DISPLAY THIS CARD ON PRINCIPAL FRONTAGE OF WORK
CITY OF PORTLAND

Permit Number: 061341

has permission to build a 2700 sq ft Single Family Home

AT 102 EAST SIDE DR Lot 68

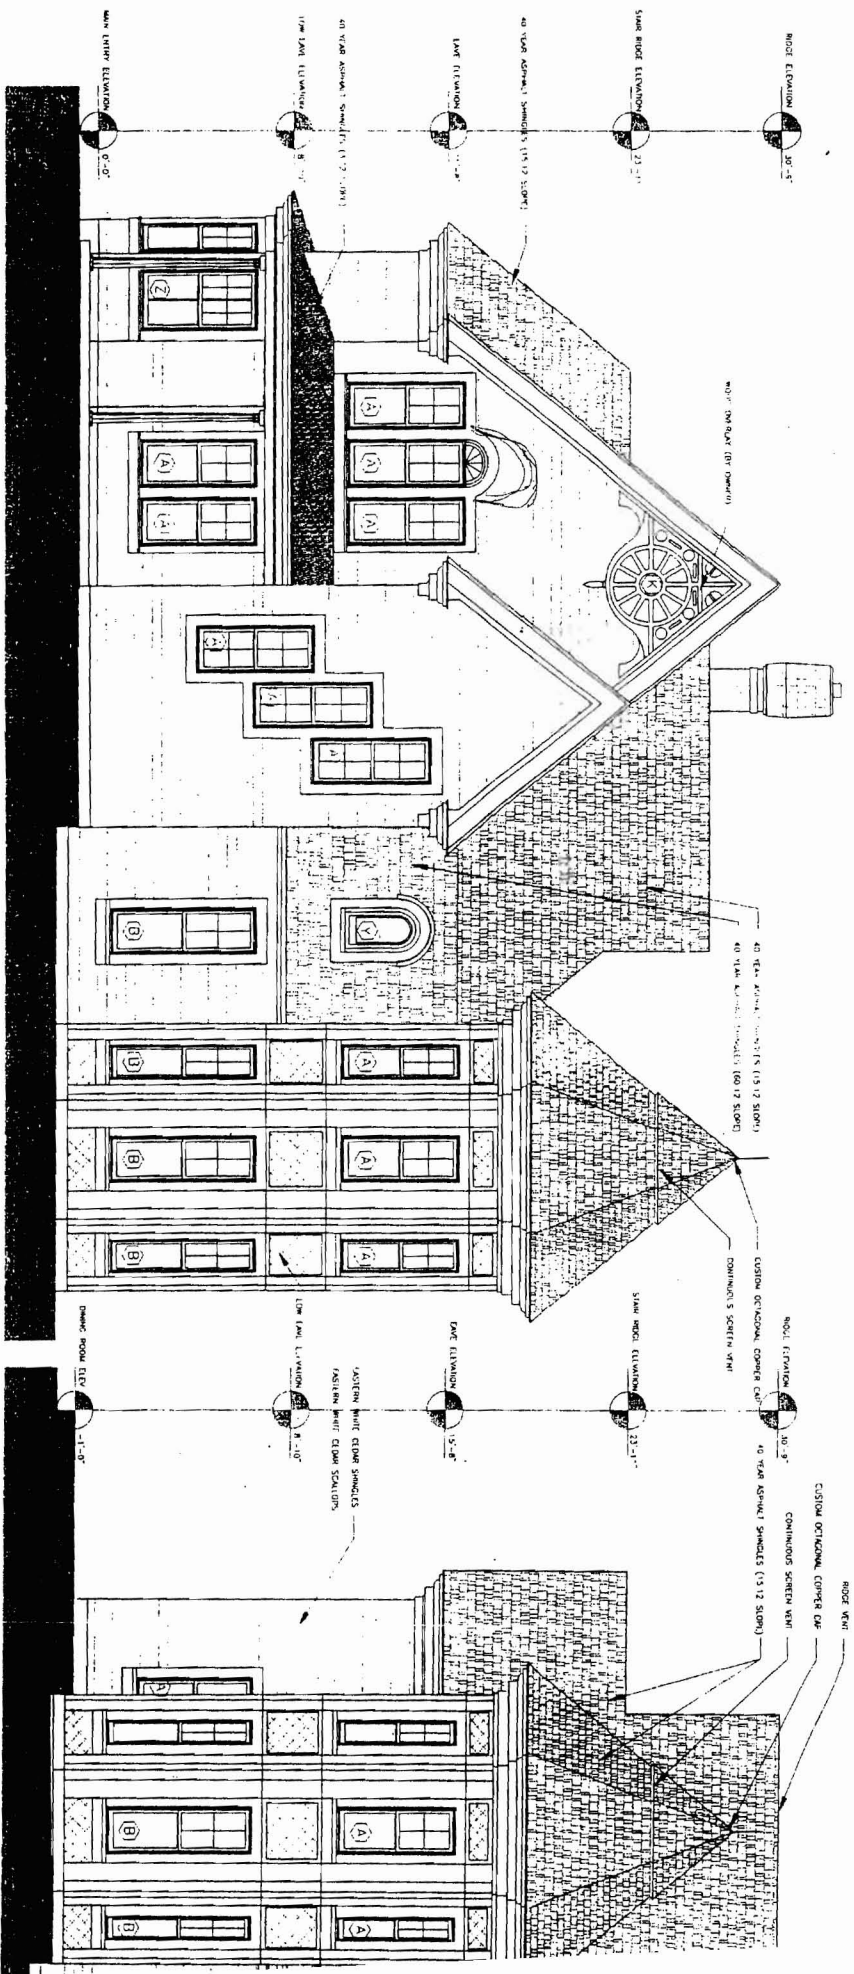
10/12/2006-amachado: Left message for Deane. Elevation plans dropped off yesterday, but they still don't show where pre construction grade is compared to the house so I can scale the height of the house. Also I need a scalable site plan that shows the 75' setback and two parking spaces.

9/19/2006-amachado: Spoke to contractor, Deane MacBeth. Need 75' setback for shoreland on plan. Need footprint of structure on site plan to match footprint of building plans. Need to show two parking spaces. Need predelopement grade on all four sides with elevations.

9/20/2006-amachado: Received revised site plan with 75' shoreland setback, but it needs to be done and stamped by a liscened surveyor. I told Deane thsi and he will get one in. I still need elevations showing the grade on all sides of the building.

11/16/2006-amachado: Deane drew the second parking space in on the site plan, so zoning is all set.
